DEVELOPMENT REVIEW BOARD
SUPPLEMENTAL SUBMITTAL

PROJECT NO. PR-2022-007229

Application No. SI-2022-01237

RE: Panda Express – S8-23-D20241
261 98th Street NW
Albuquerque, NM 87121
RE: DRB Planning Review – Resubmittal
DRB Project Number: 2022-007229
App. Number: SI-2022-01237

PANDA HOME - CUSTOM  
261 98TH ST. SW  
ALBUQUERQUE, NM 87212

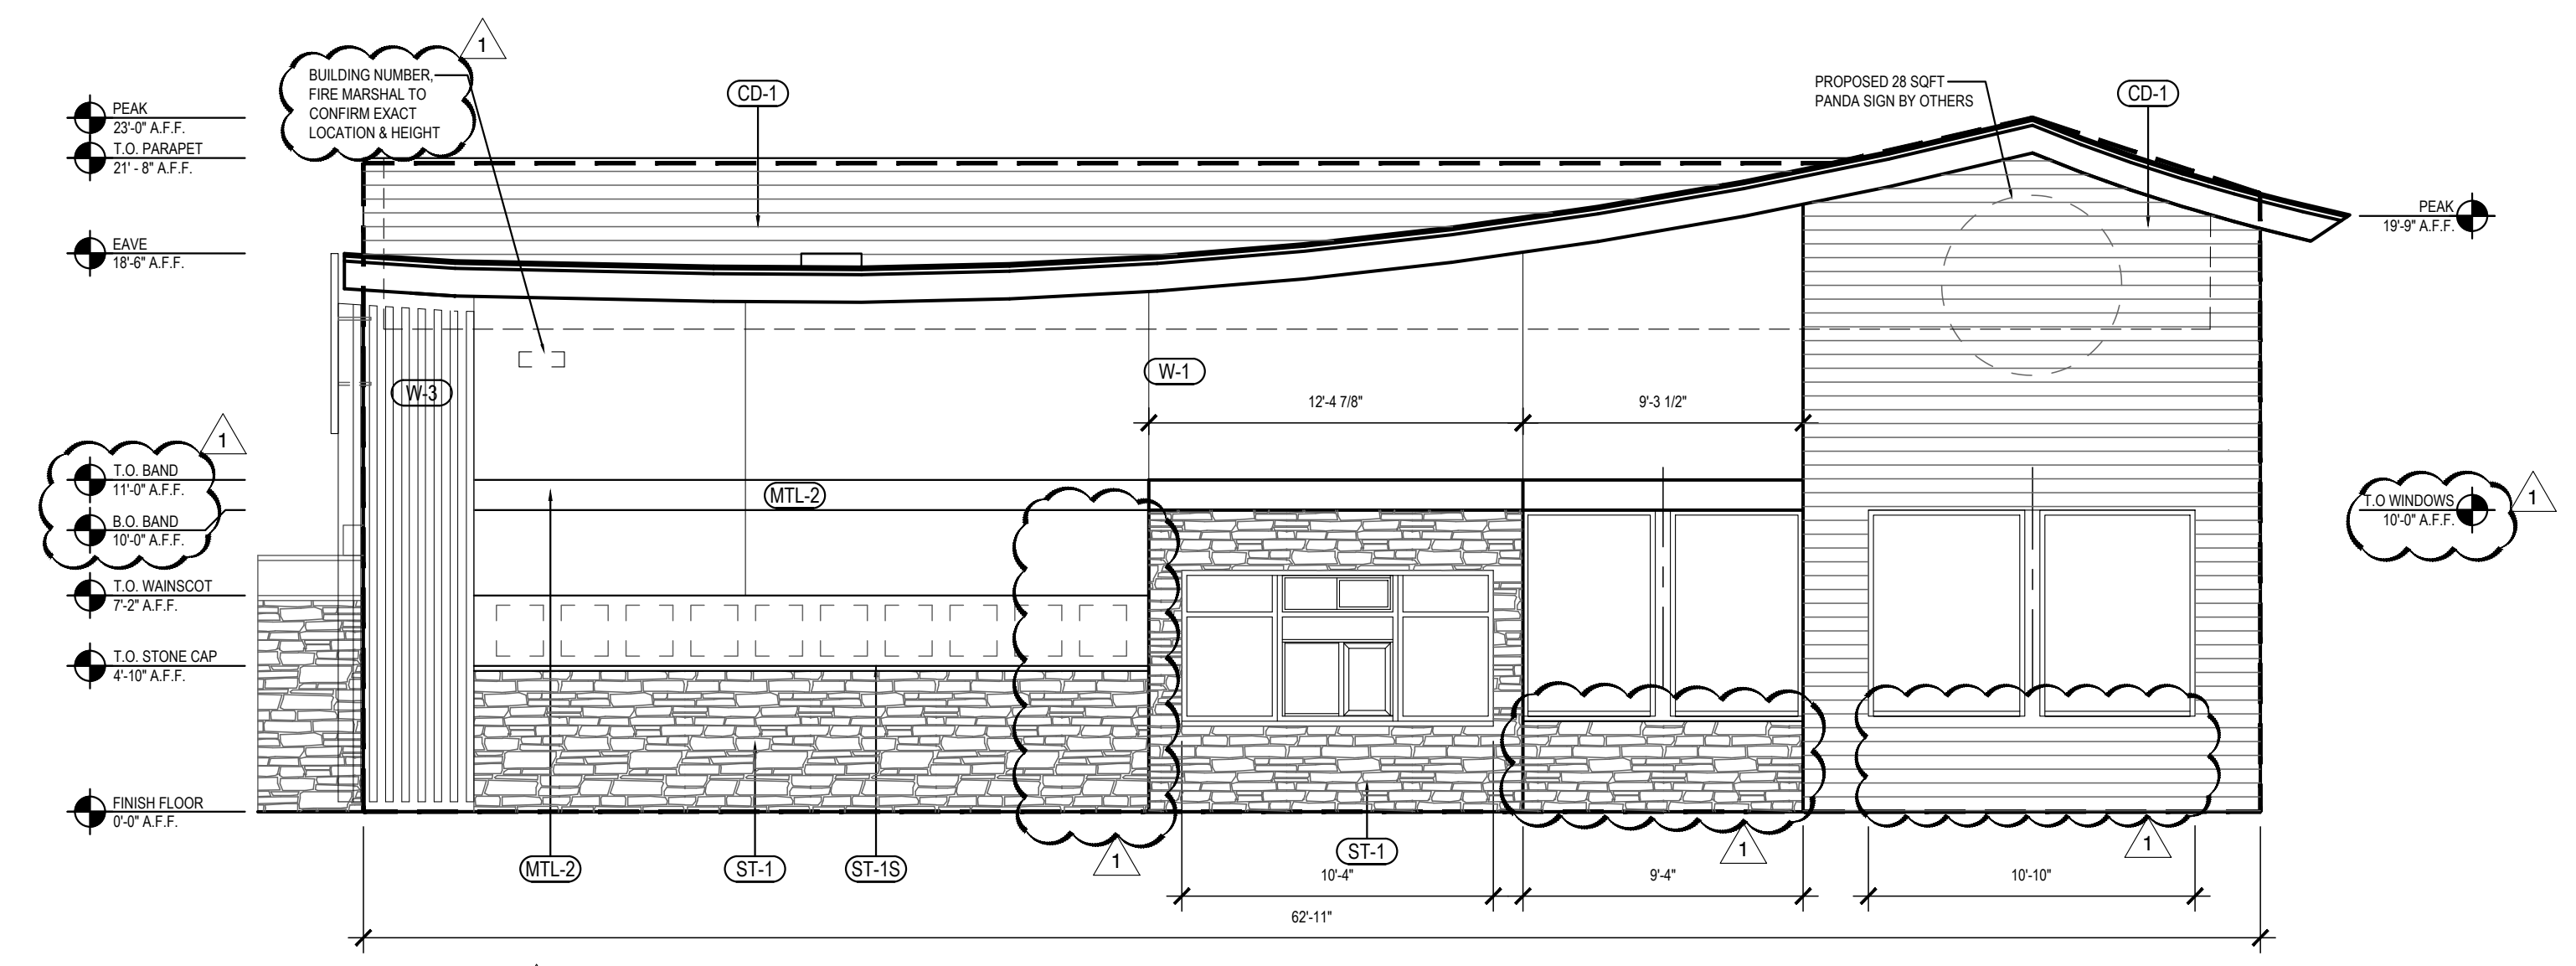
- The applicant is requesting a Deviation from the requirements for each ground floor of a street-facing façade to have a minimum of 30 percent of its surfaces in transparent windows per 5-11(E)(2)(a)2 of the IDO, noting that the proposed development is providing 25.1% of the surface of the street facing façade. To permit a DRB-approved Deviation, the reduction in the surface of a street facing façade being transparent windows. The amount of reduction in the surface of a street facing façade being transparent windows as proposed will require ZHE approval of a Variance.

Response: *Per IDO Section 5-11 E (2) (a) 2, each street facing façade shall incorporate at least 2 features along at least 30% of the length of the façade. Please reference to detail 2/A-202 for calculations under length of building.*

Response: *Acknowledge. Please reference detail 2/A-202, exterior elevations.*

SITE PHOTOMETRIC PLAN

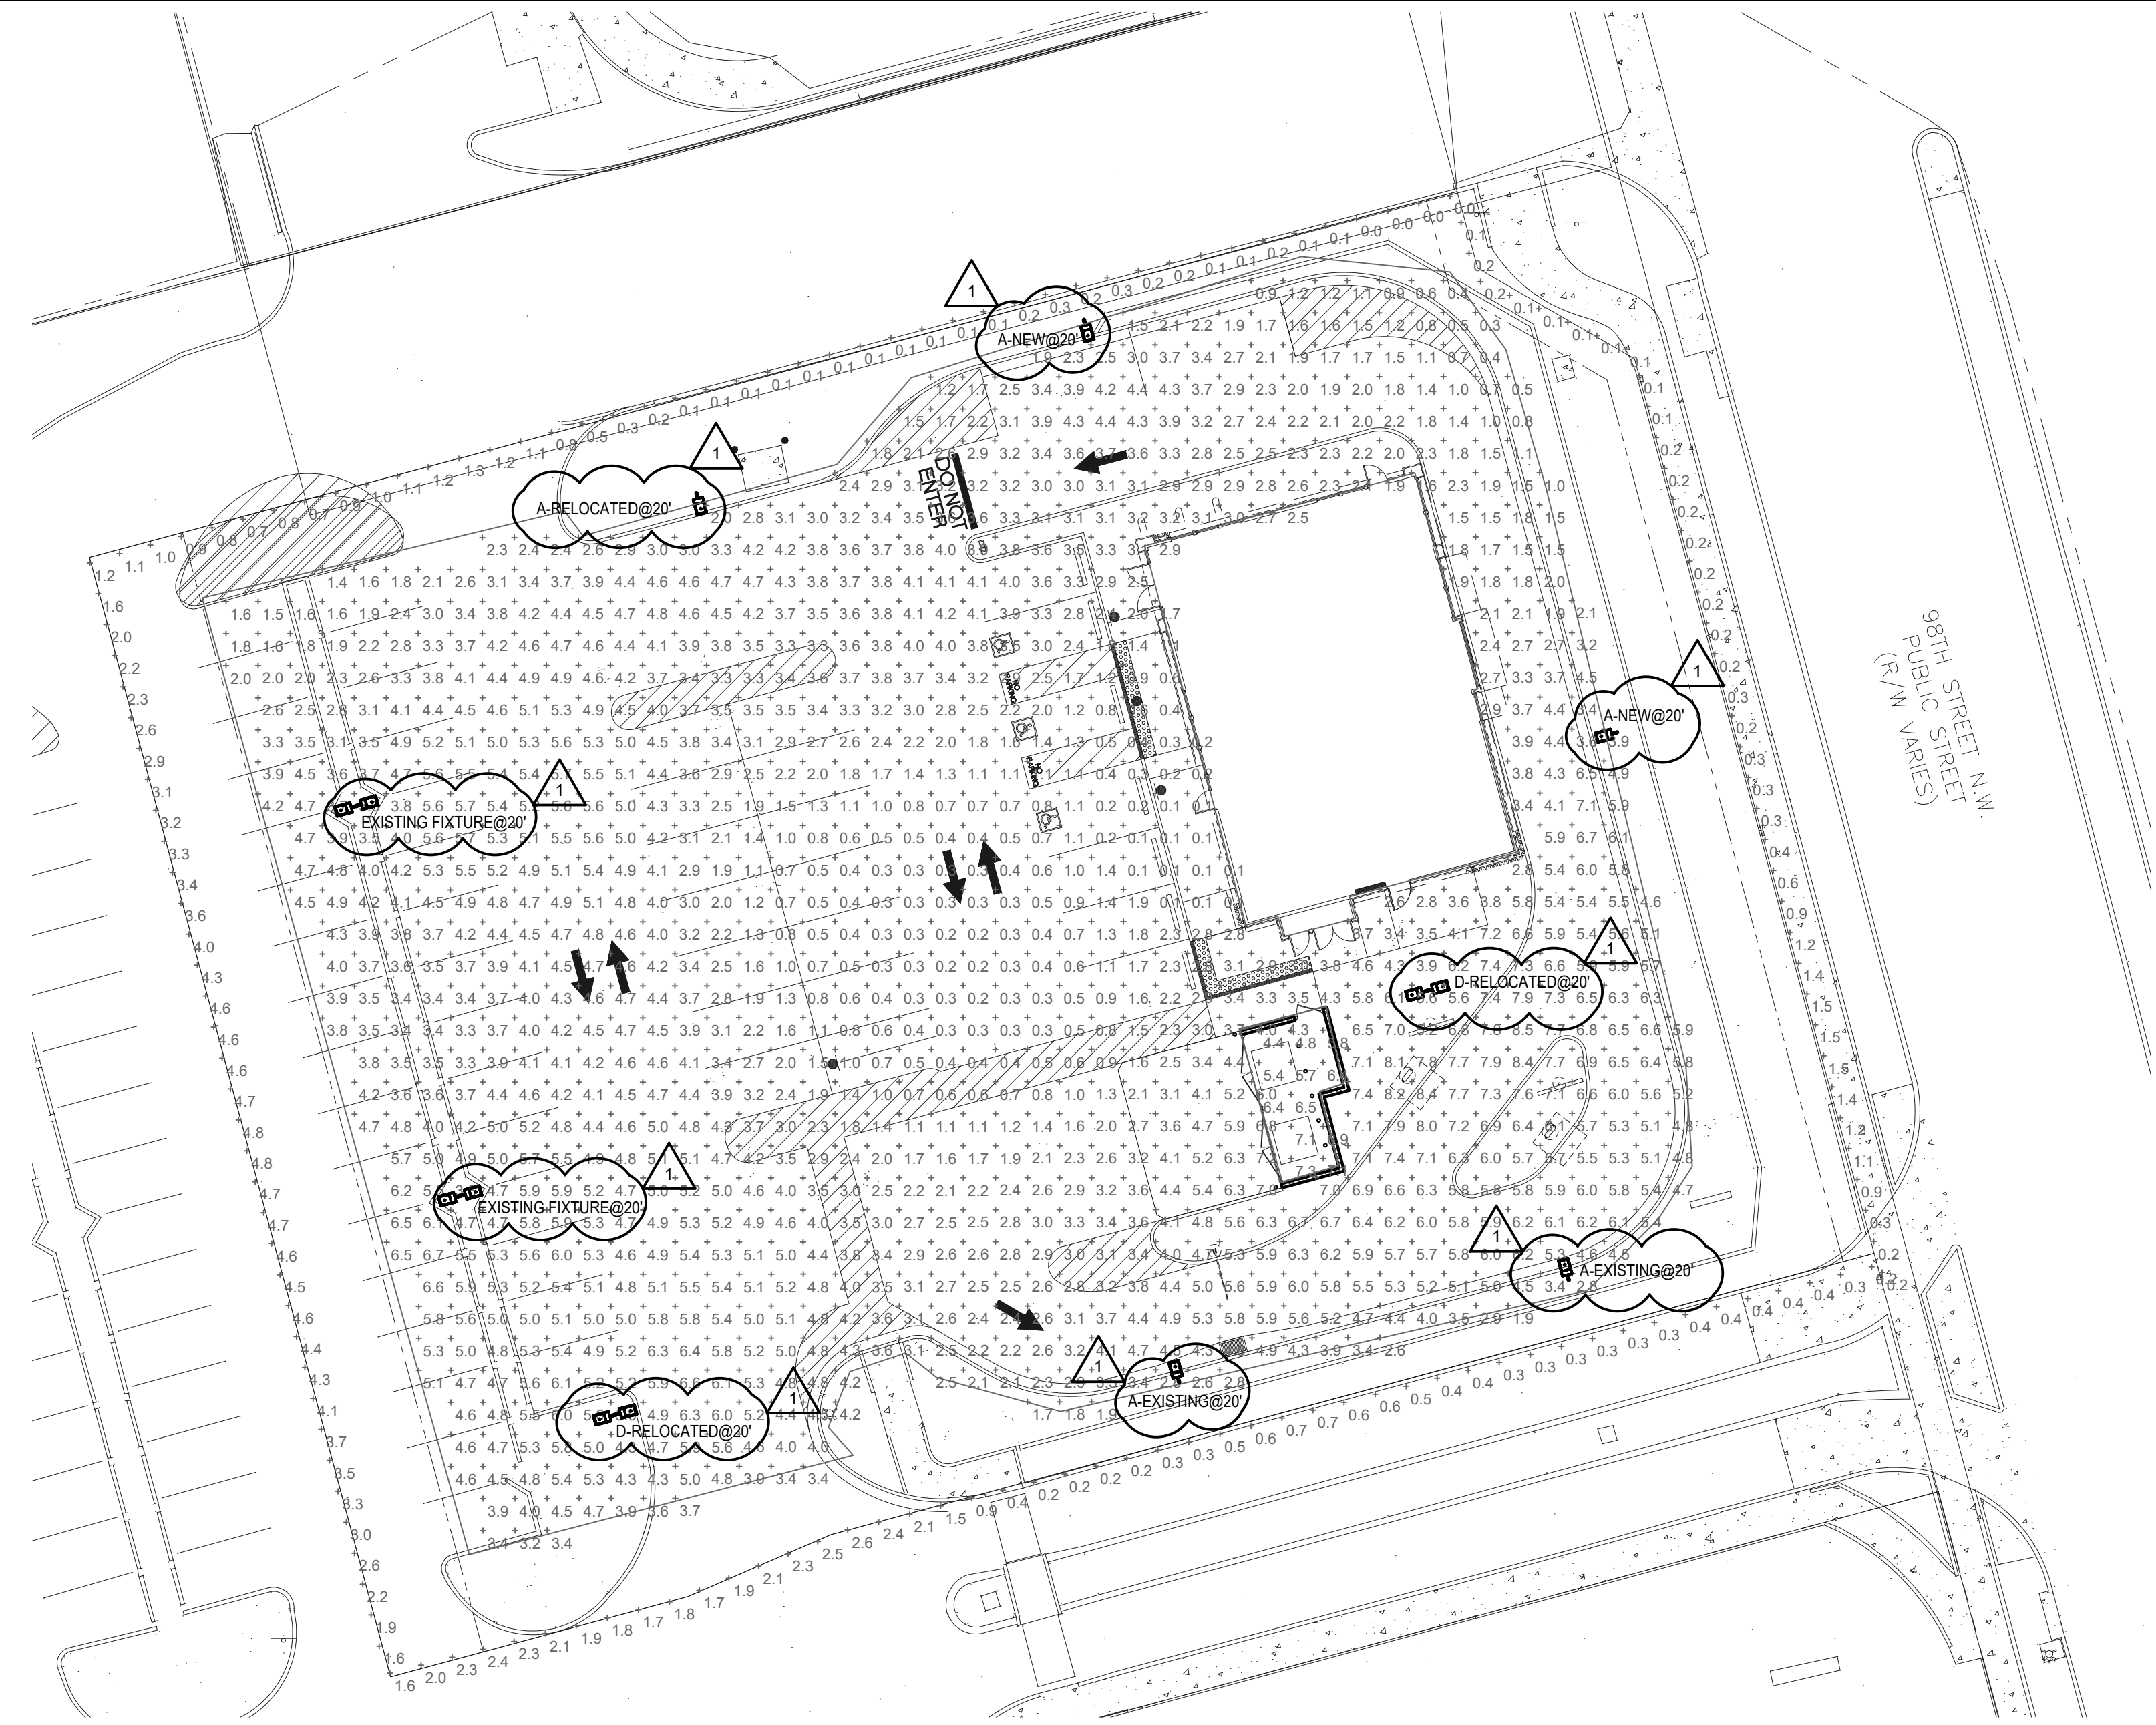
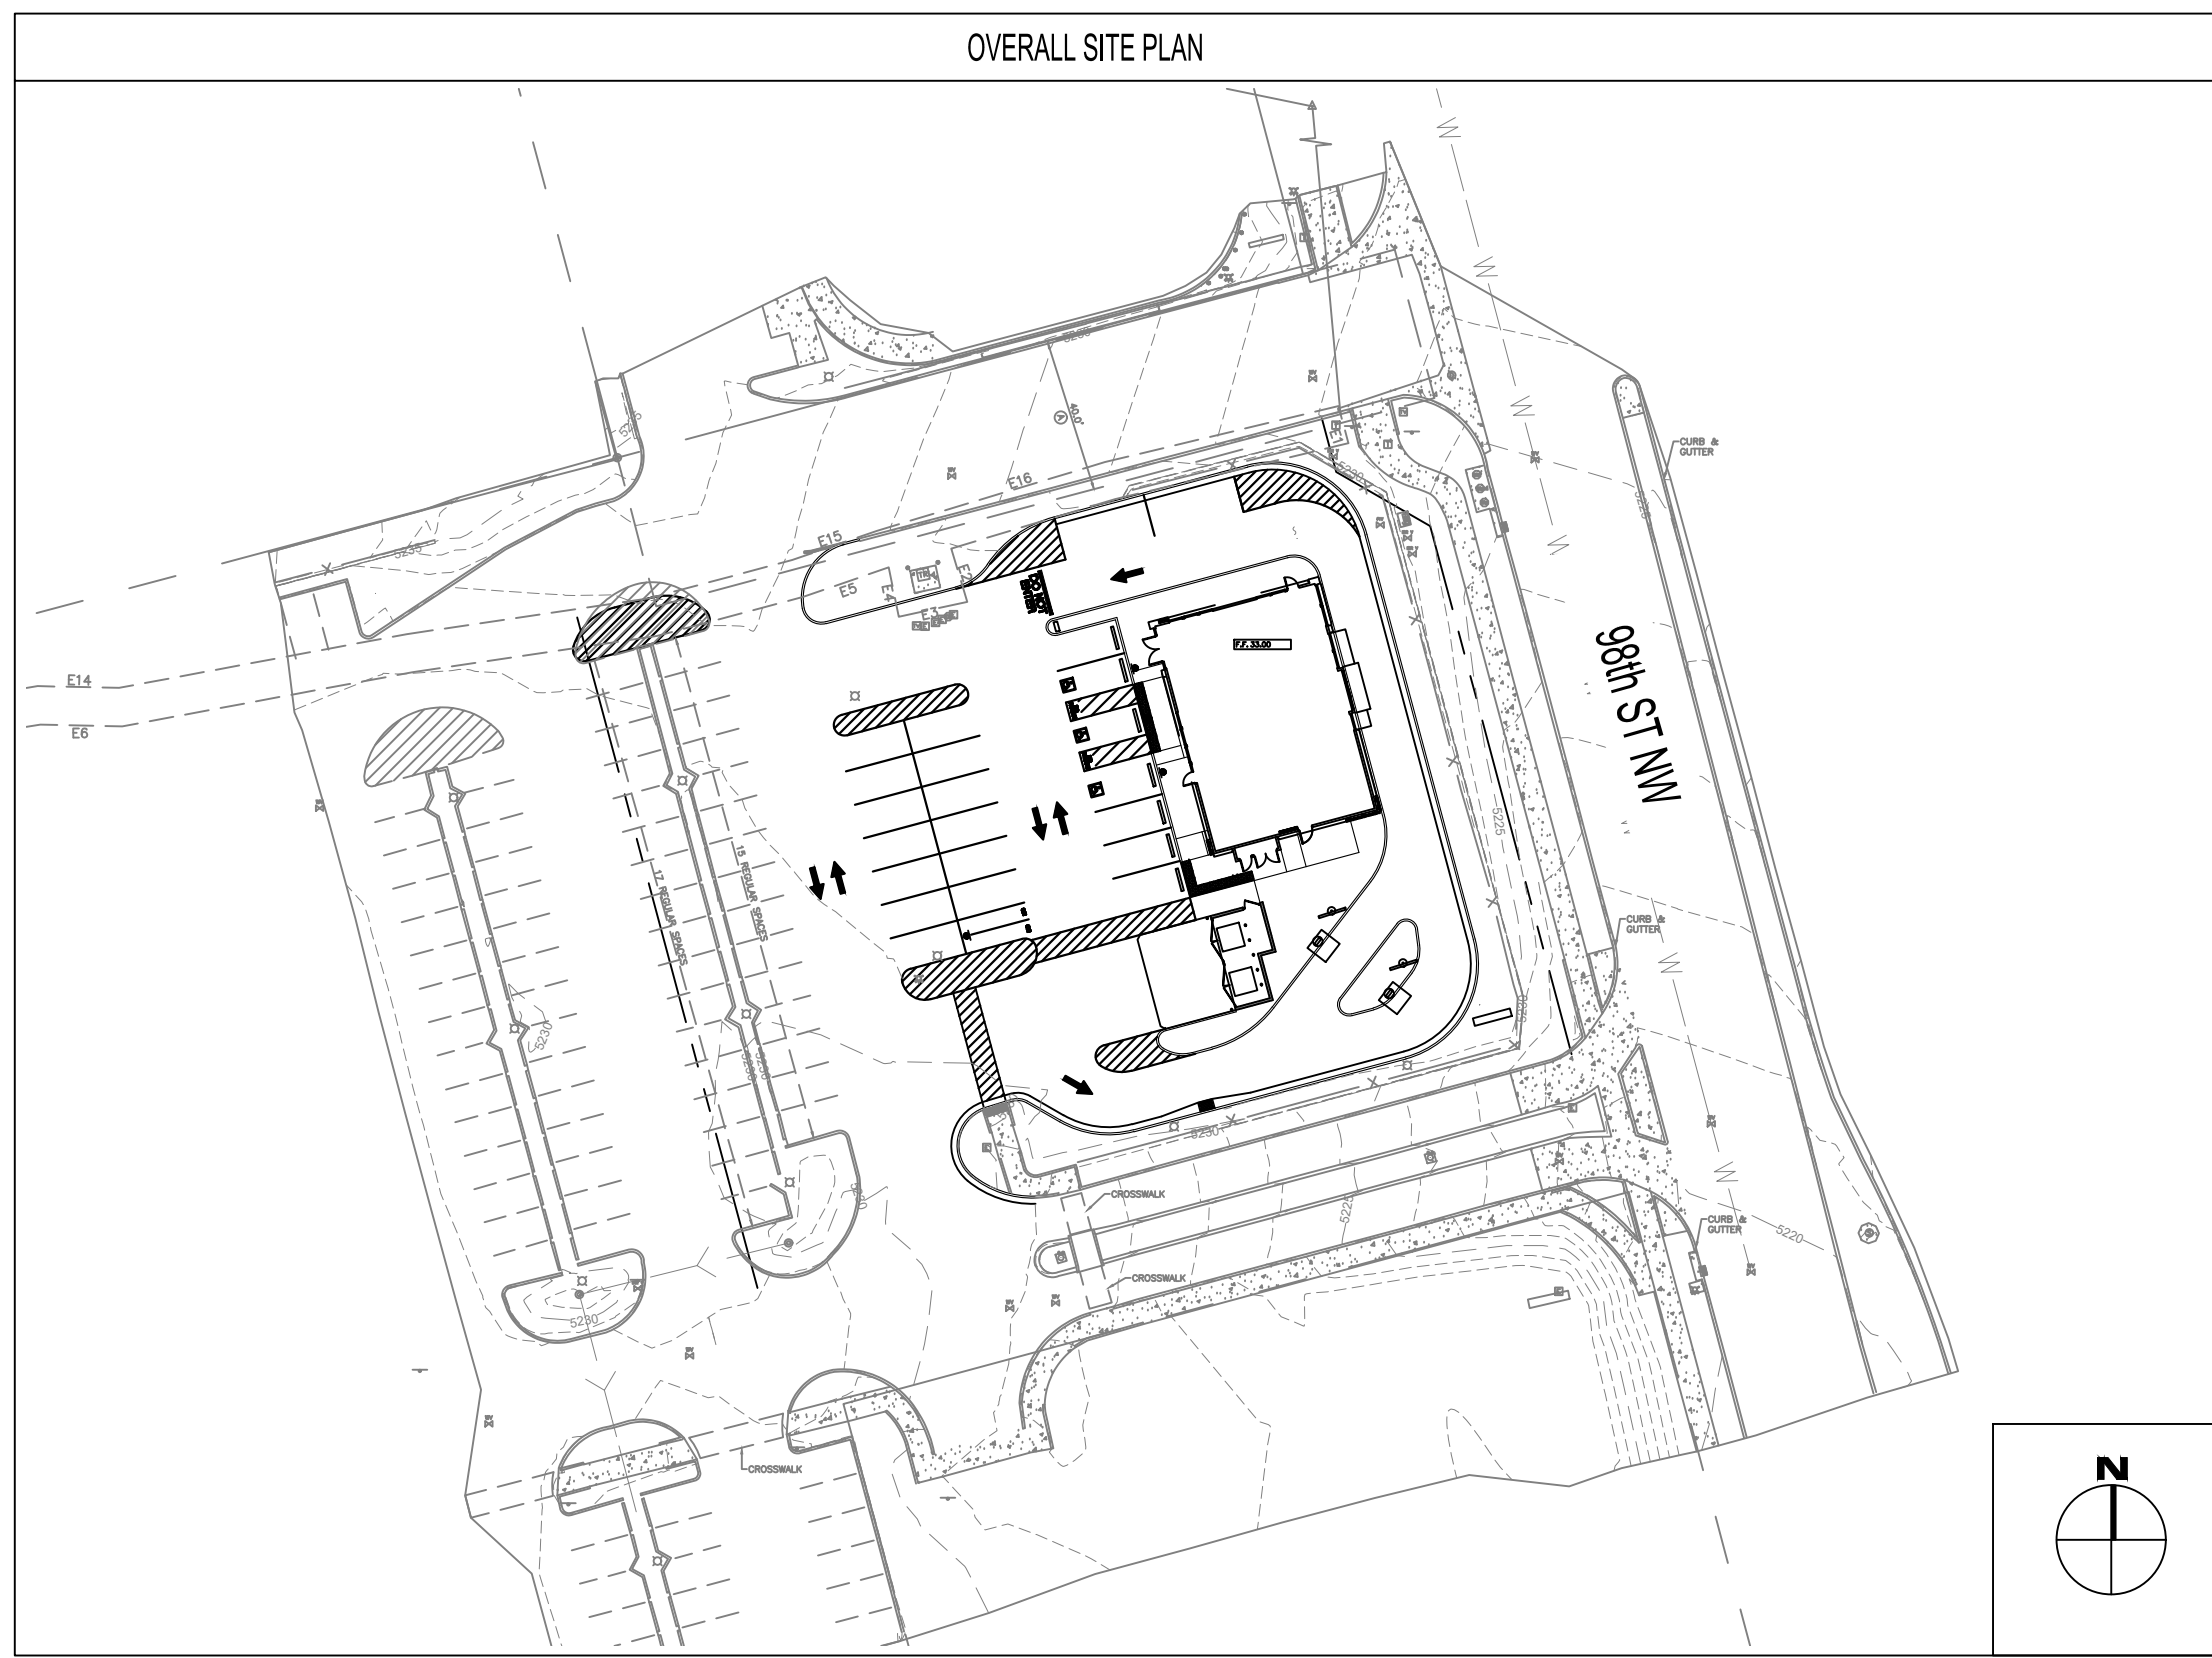
5. Lighting must meet requirements of IDO Section 5-8 Outdoor and Site Lighting.

Response: *Acknowledge. Please note that HV is working on revising the photometric per the IDO Section 5-8. Please reference revised detail 4/E-105, indicating overall height per IDO Section 5-8.*
